Tween Bridge Solar Farm

8.5 Written Summary of Oral Submissions at the Issue Specific Hearing 1

Document Reference: 8.5

Deadline 1 May 2026

Document Ref: 6.4.6.4 AFPP Reg: 5(2)(a) Revision: 2
 PINS Number: EN010148 Drawing Status: Final
 Drawn: LAB Checked: HS Approved: KC Date: 17/04/2026

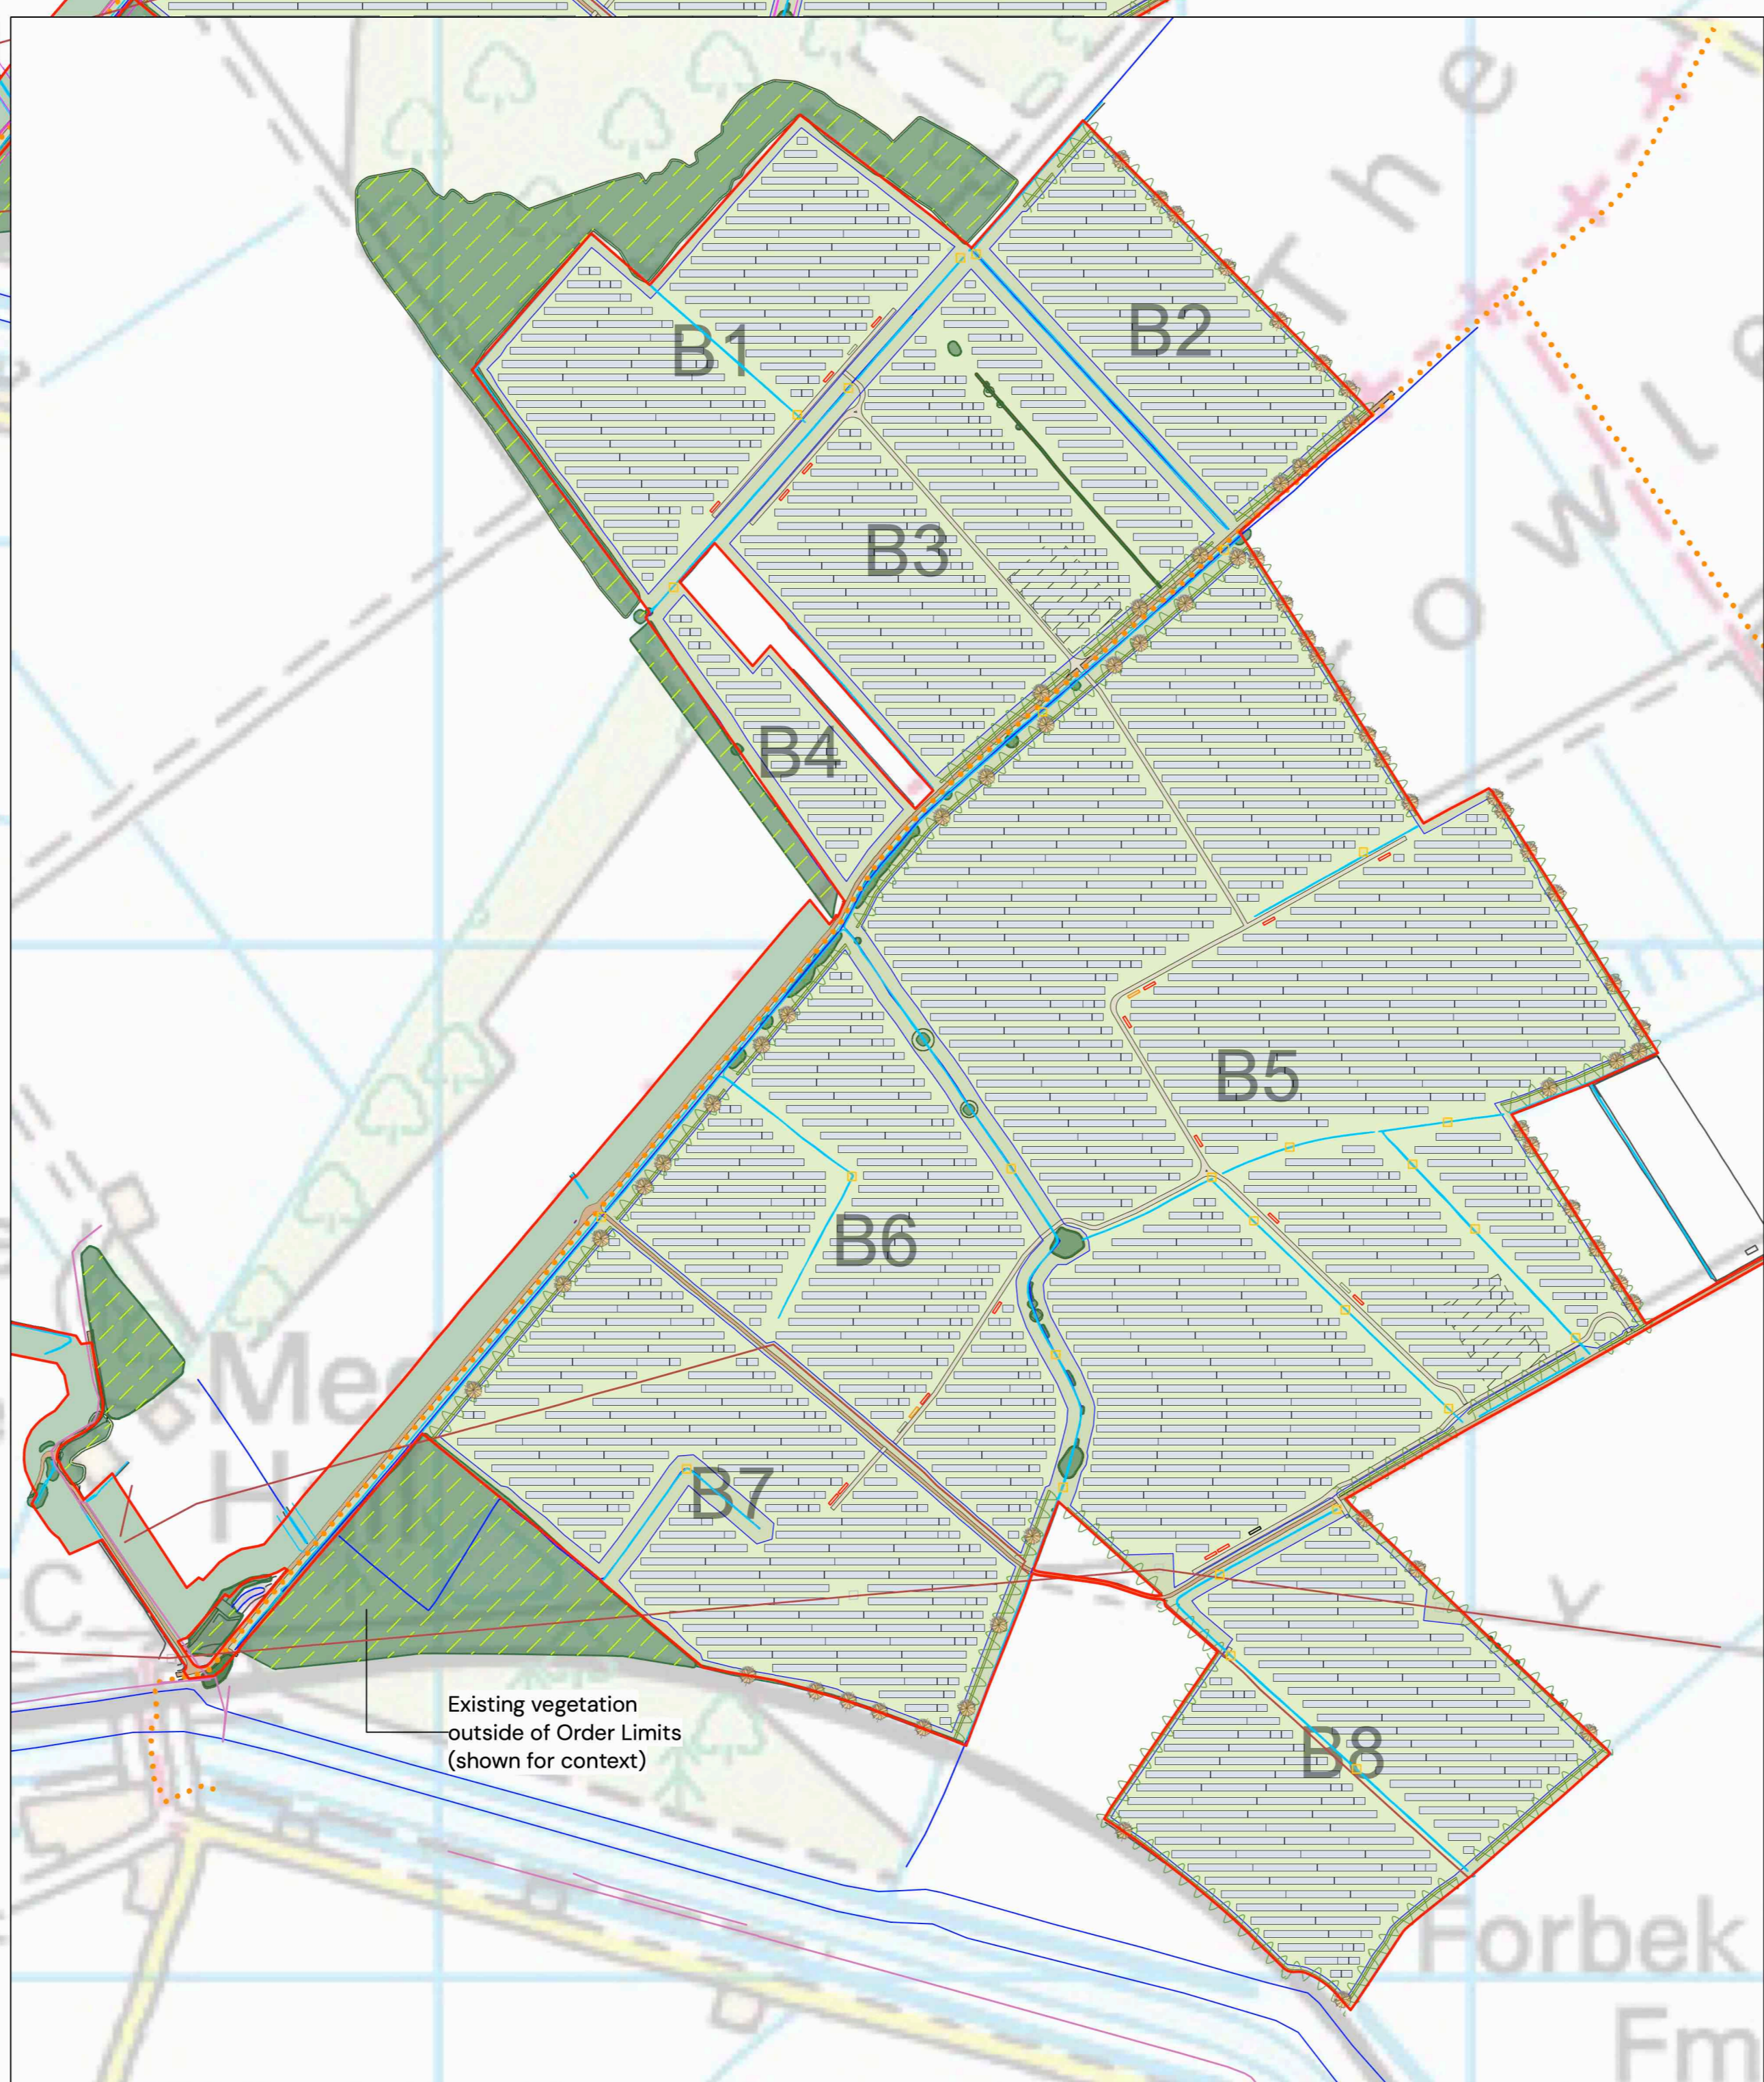
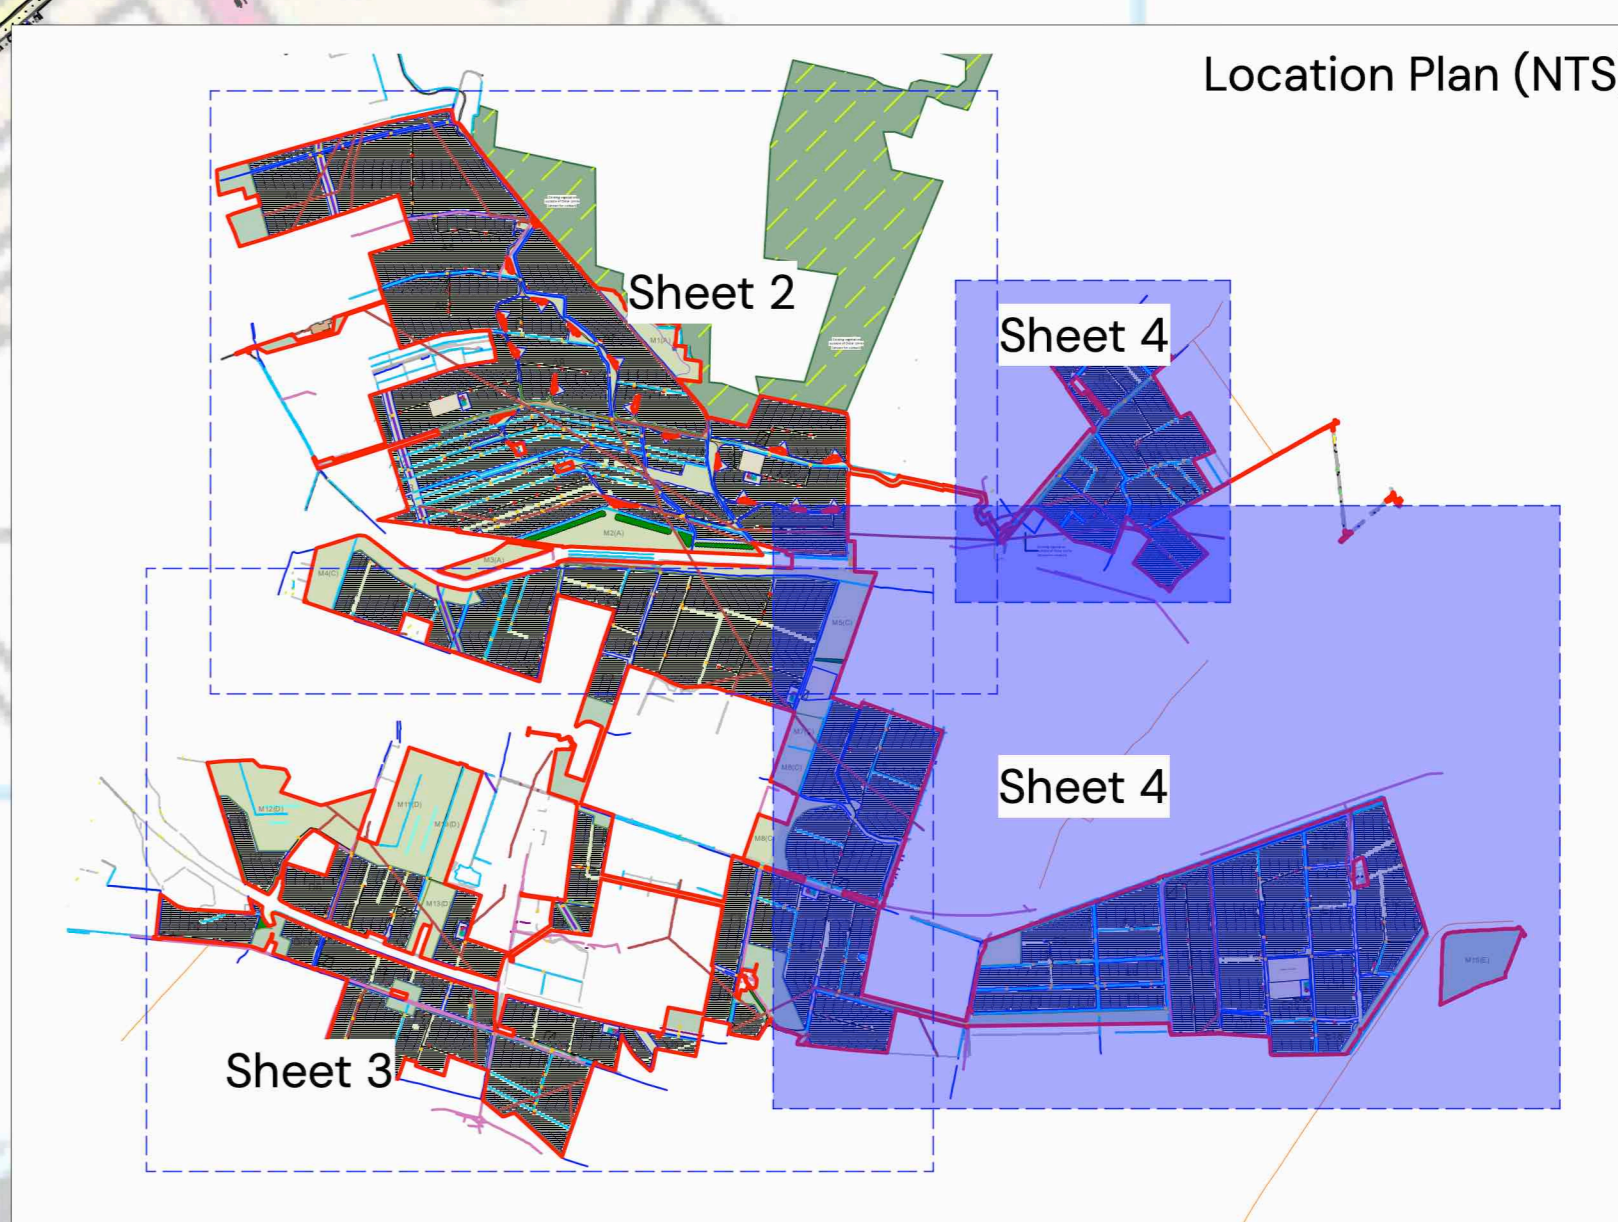
- 5.33. The Councils queried an ambiguity in respect of the identification of the onsite 400kV substation on **ES Figure 6.4 Landscape and Visual Mitigation Strategy [Document Reference 6.4.6.4 Revision 2], ES Figure 6.5 Residential Properties [APP-149] and Appendix 6.4 Photomontage Visualisations Part 1 [APP-O68] and Part 2 [APP-O67].**

- 5.34. KC noted that the Applicant would clarify in writing following the hearing the identification of the onsite substation within these documents.
- 5.35. **Action 6: Provide an explanation of why the substation identification appears differently on ES Figures 6.4 Landscape and Visual Mitigation Strategy and 6.5 Residential Properties [APP-149] and Appendix 6.4 Photomontage Visualisations Part 1 [APP-O68] and Part 2 [APP-O67] and update Figure 6.4 if there is an error.**

- 5.36. **Post-hearing note: ES Figure 6.4 Landscape and Visual Mitigation Strategy has been updated to include the 400kV Substation in field reference E16 and the revised version has been submitted at Deadline 1. The substation formed part of the assessment and was simply omitted in error from this drawing.**
